Date: 1-8-11

From: Roger Evans

Subject: Comments Former Cereal Partners site – Broadwater Road

05. NORTH ELEVATION

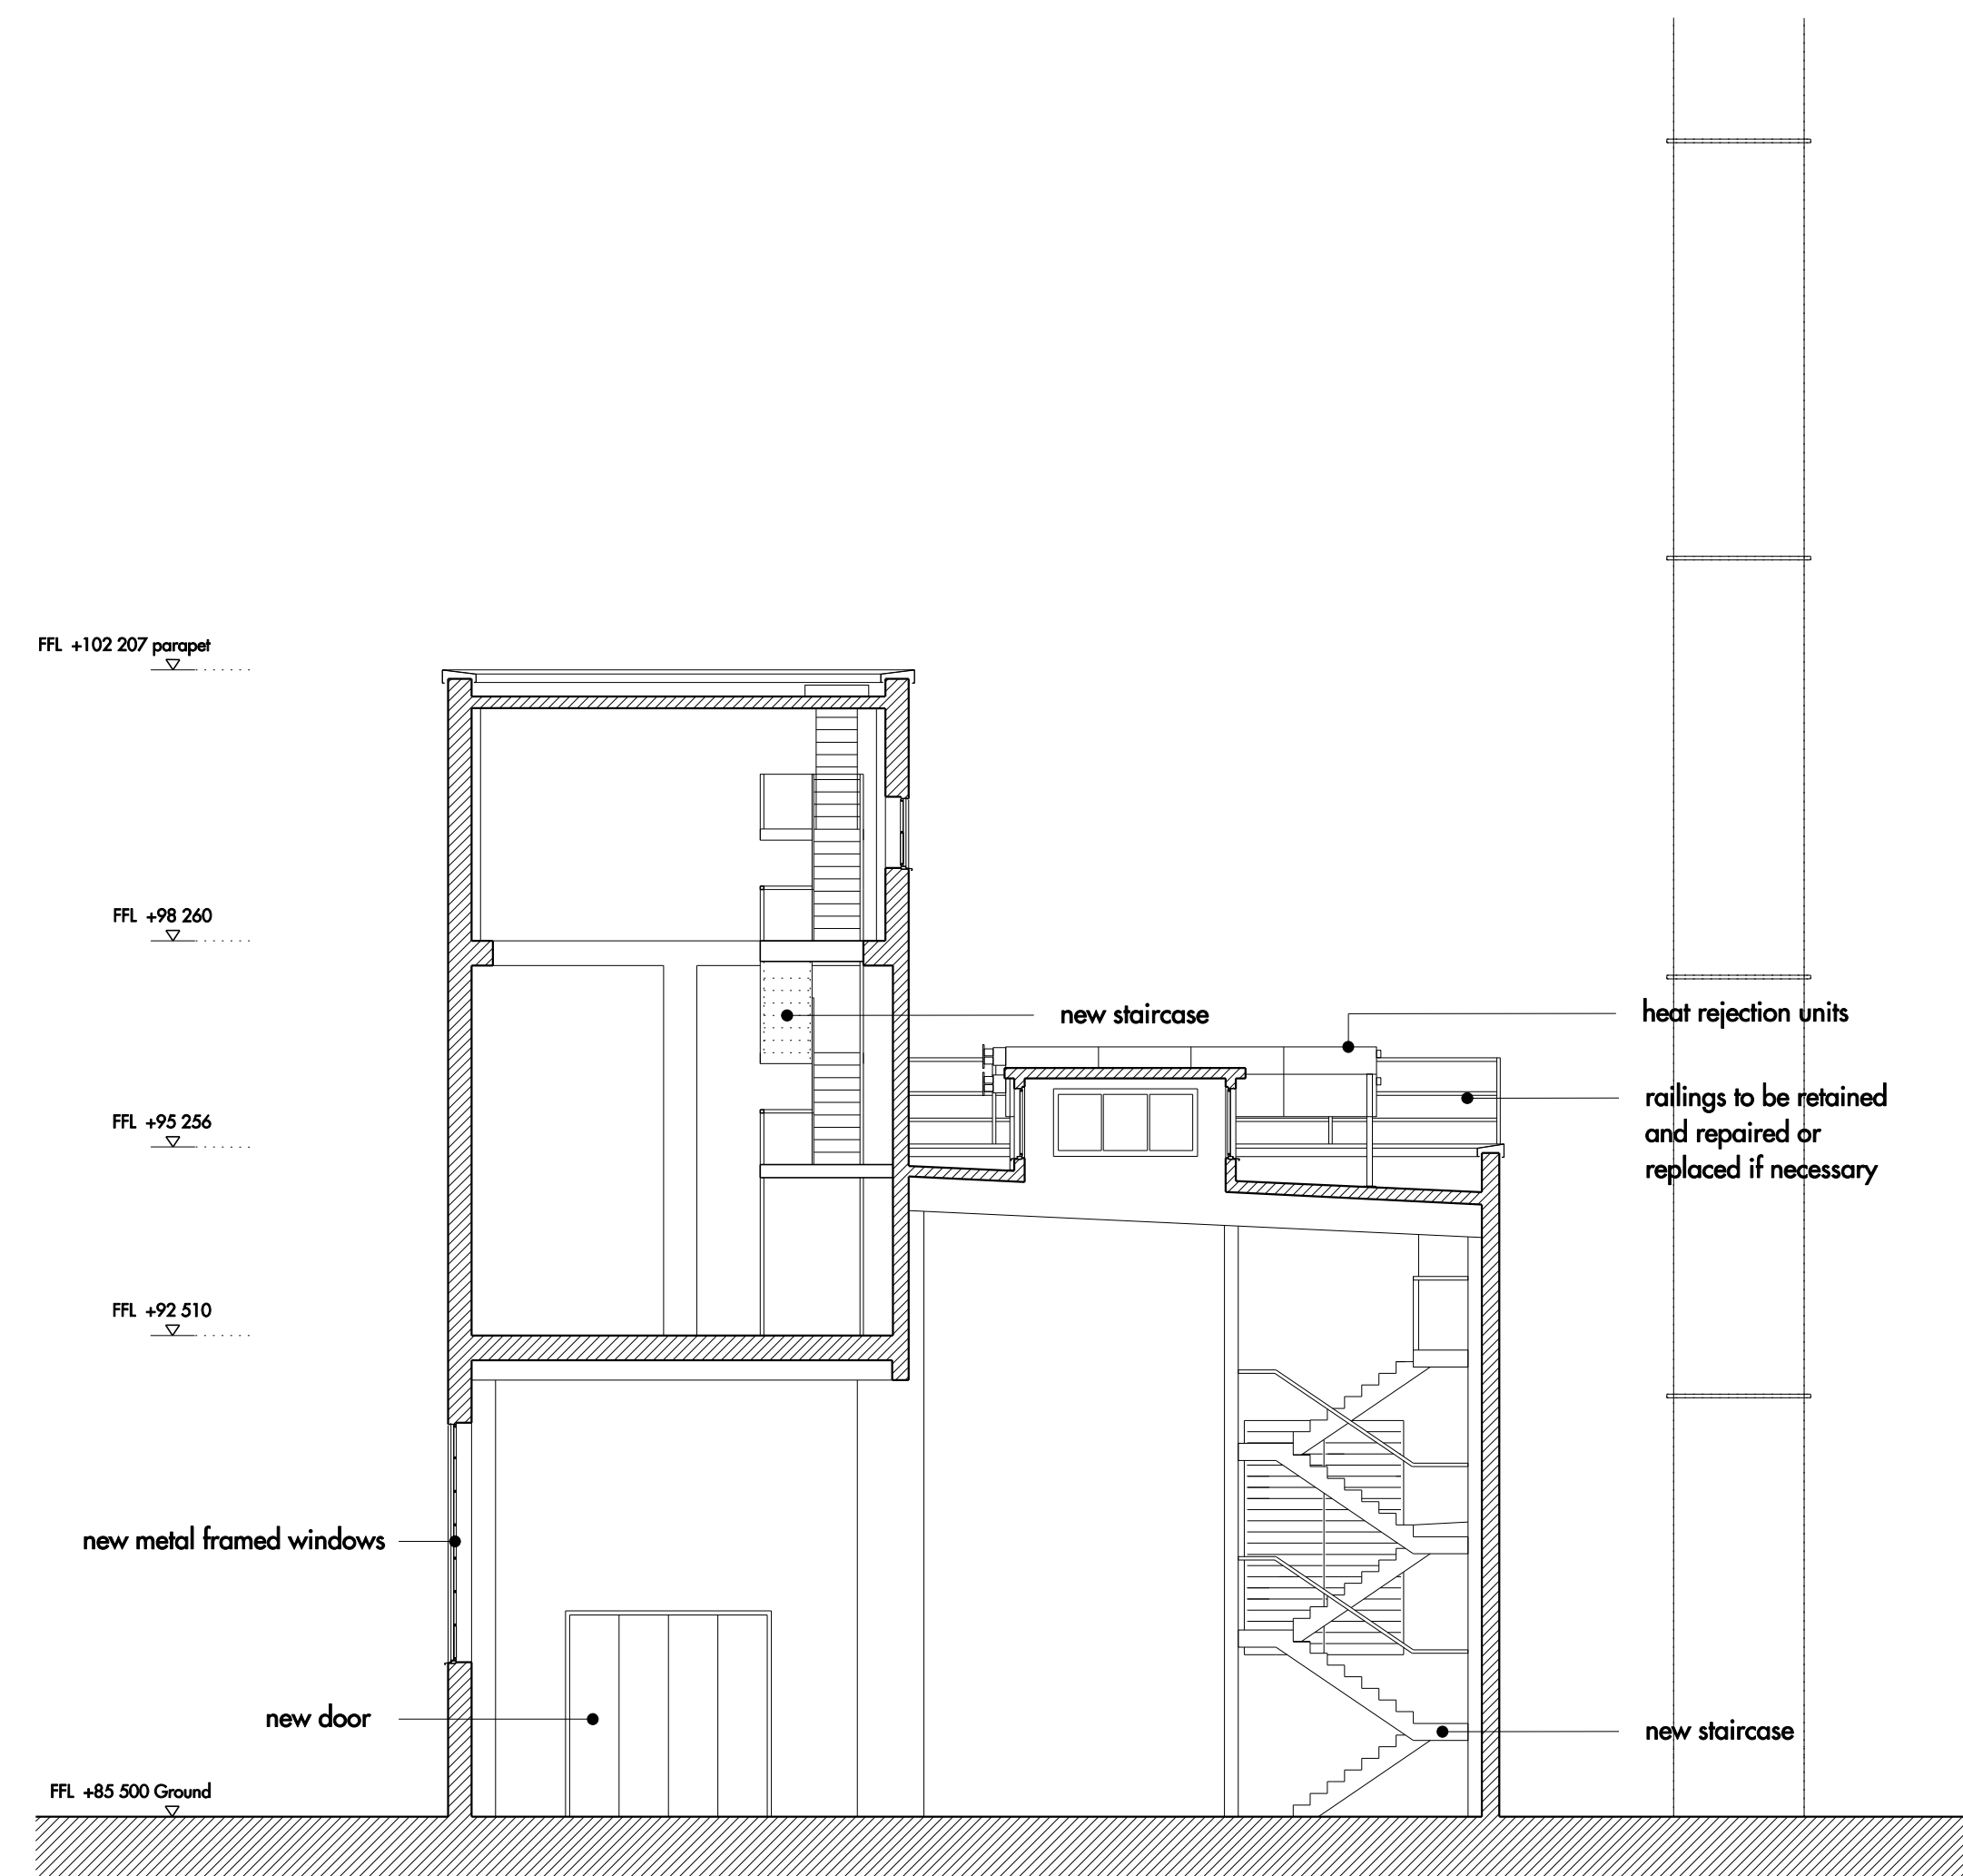
The assessment of noise from the CHP indicates that the “target” maximum noise level is 33 dBA at 10m from the building is achievable, based on information from the potential supplier. For this to be possible the two external heat rejection units will have to be “low noise” models capable of a maximum noise output of 30 dBA at 10m (consequently a combined level of 33dBA) . In addition the attenuation provided behind the louvers and to ventilation duct openings would need to be able to reduce the noise level from the remaining plant to 20dBA at 10m. *The combined total would not in this case exceed the 33dBA level required.* The output from the heat rejection units will be readily available, details of the performance of equipment to attenuate the louvers and the ventilation ducts will need to be provided .

Insofar as conditions are concerned I would suggest – A scheme of attenuation for the CHP should be submitted and agreed by the planning authority. This should indicate plant noise levels, including frequency analysis, and the attenuation details in respect of internal and external plant, calculated to ensure the noise level at 10m from the building, relating to the CHP operation, does not exceed 33dBA.
